SAND CREEK STABILIZATION, BRIARGATE BOULEVARD & STERLING RANCH ROAD BRIDGE DESIGN PLANS

STERLING RANCH DEVELOPMENT

EL PASO COUNTY, COLORADO

Engineering Review
11/19/2020 11:49:23 AM
ddrice
JeffRice@elpaso.com
(719) 520-7877
EPC Planning & Community Development Department
See comment letter.
Cursory comments.

**SAND CREEK STABILIZATION, BRIARGATE BOULEVARD &
STERLING RANCH ROAD BRIDGE DESIGN PLANS
STERLING RANCH DEVELOPMENT
STA 19+00 TO STA 9+00
EL PASO COUNTY, COLORADO**

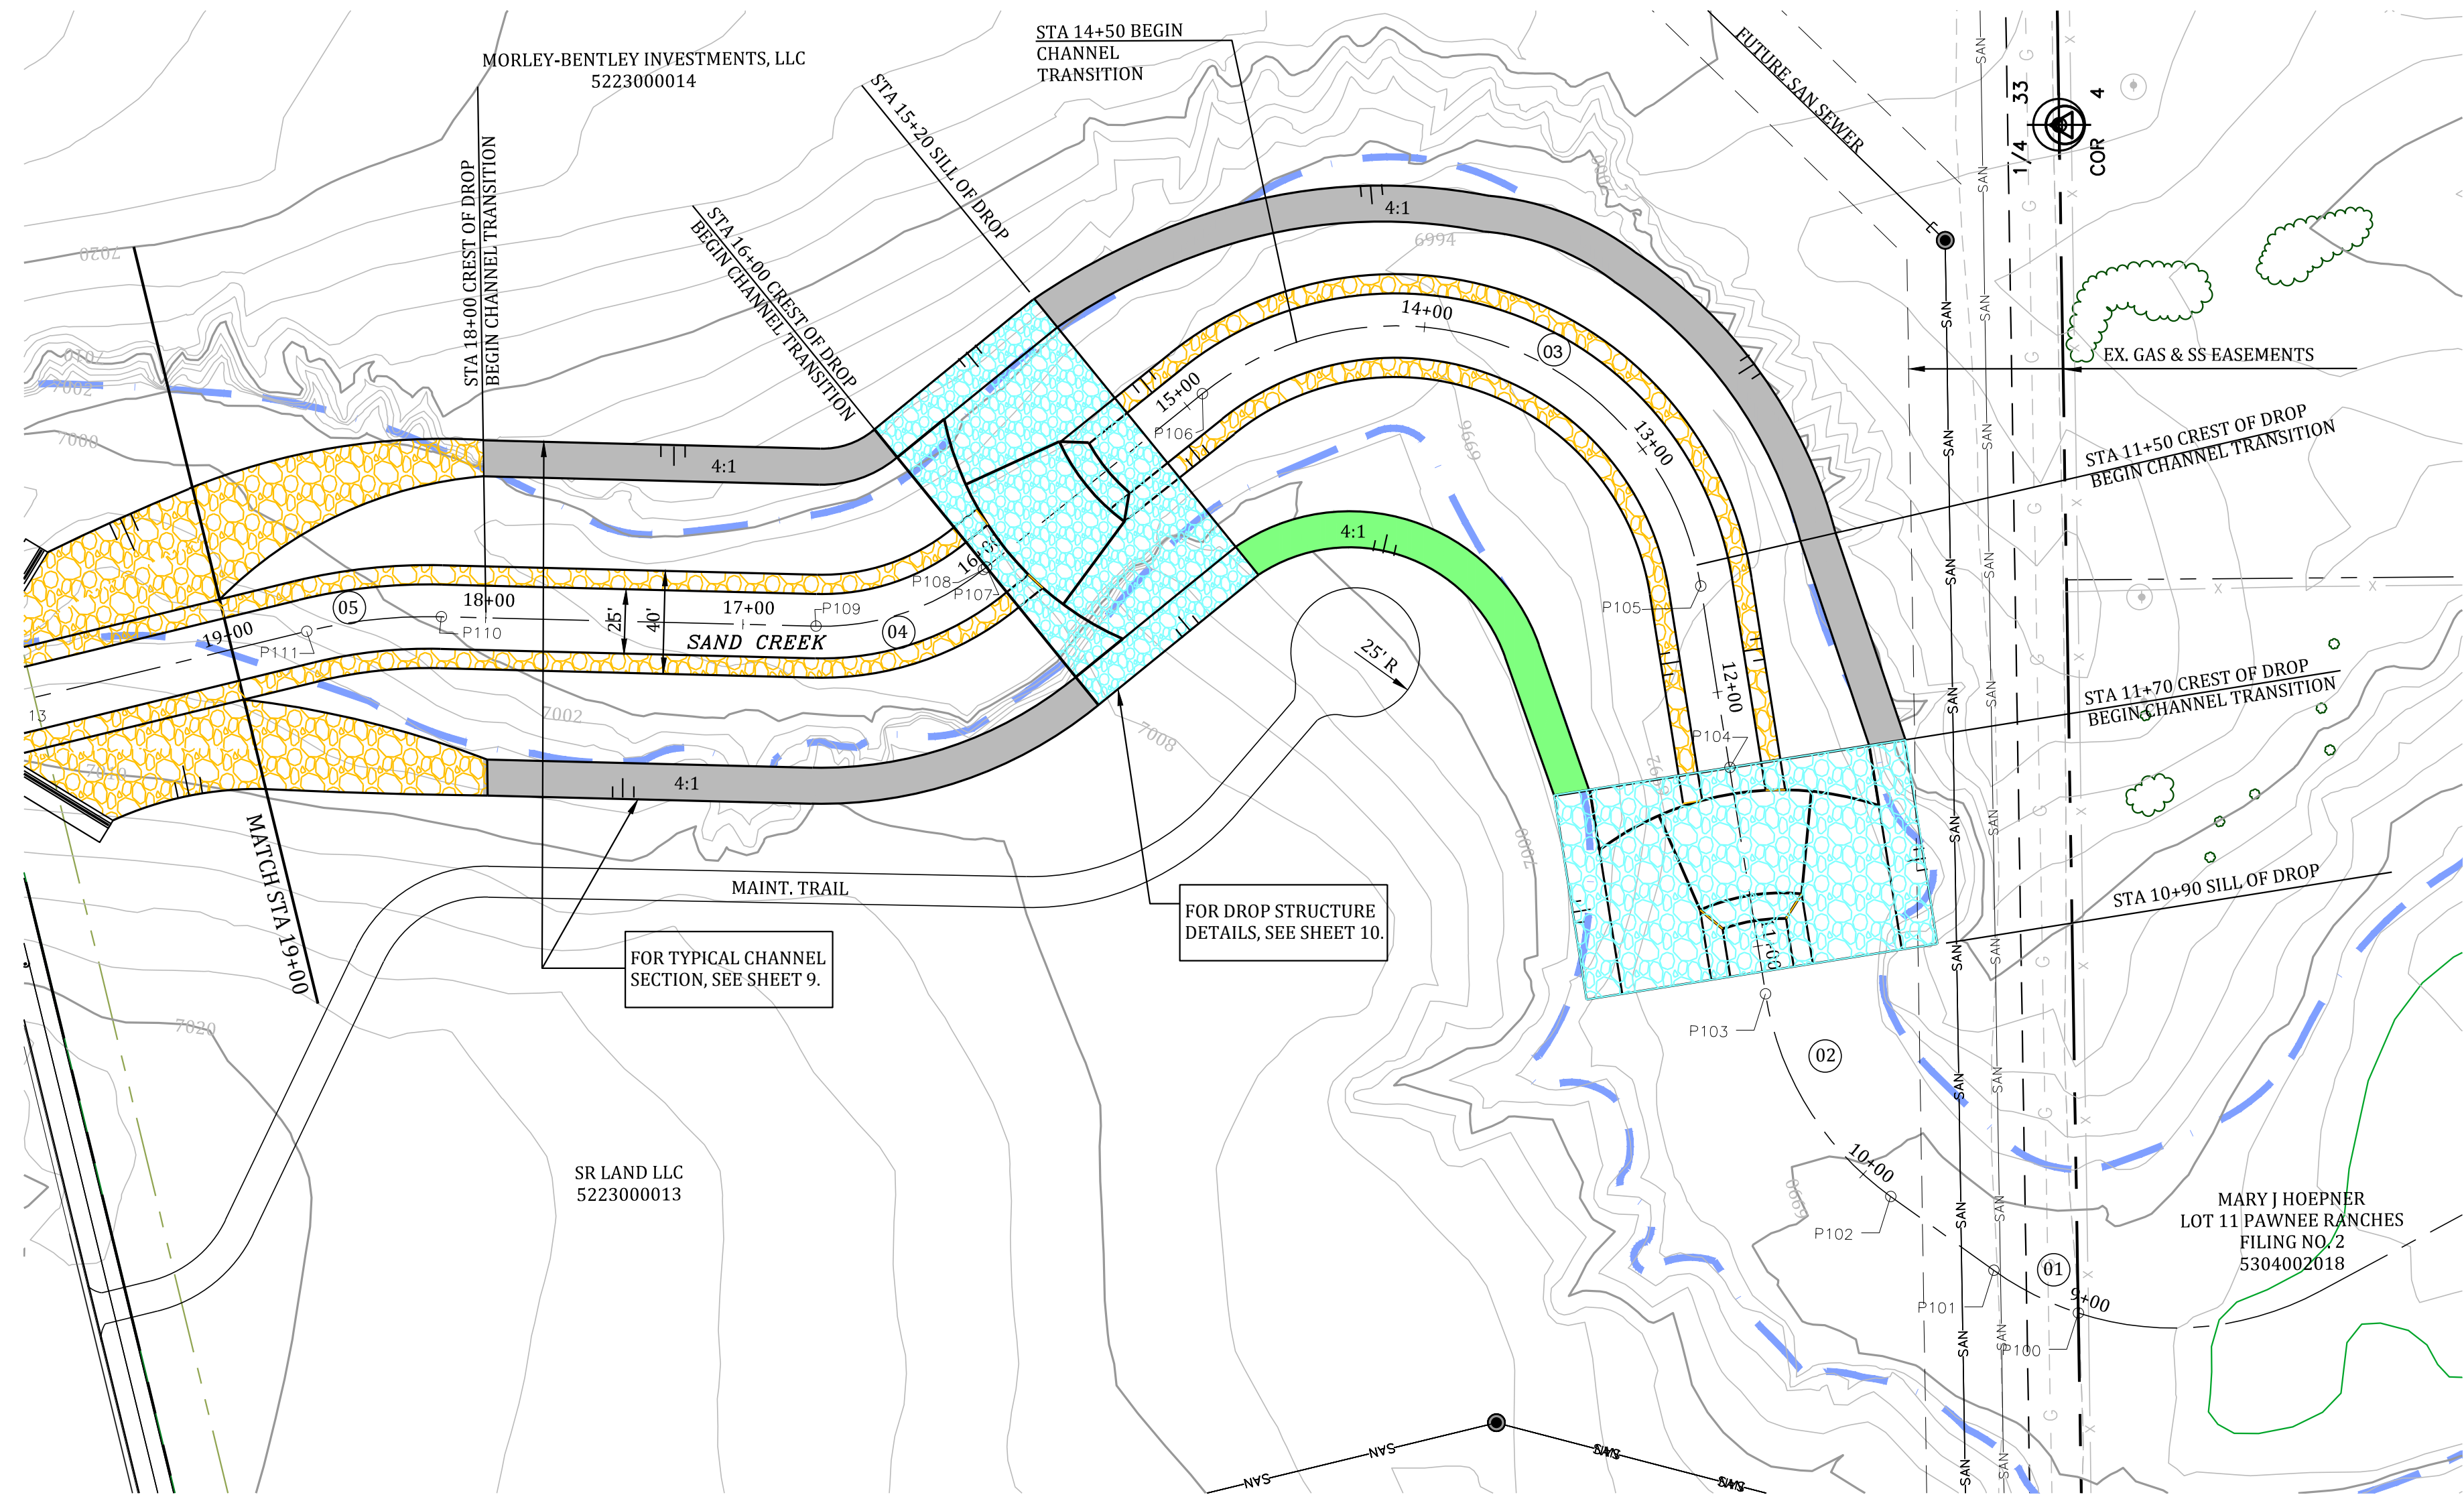
Most of these radii
don't meet DCM
Section 3.3.3.E.2?
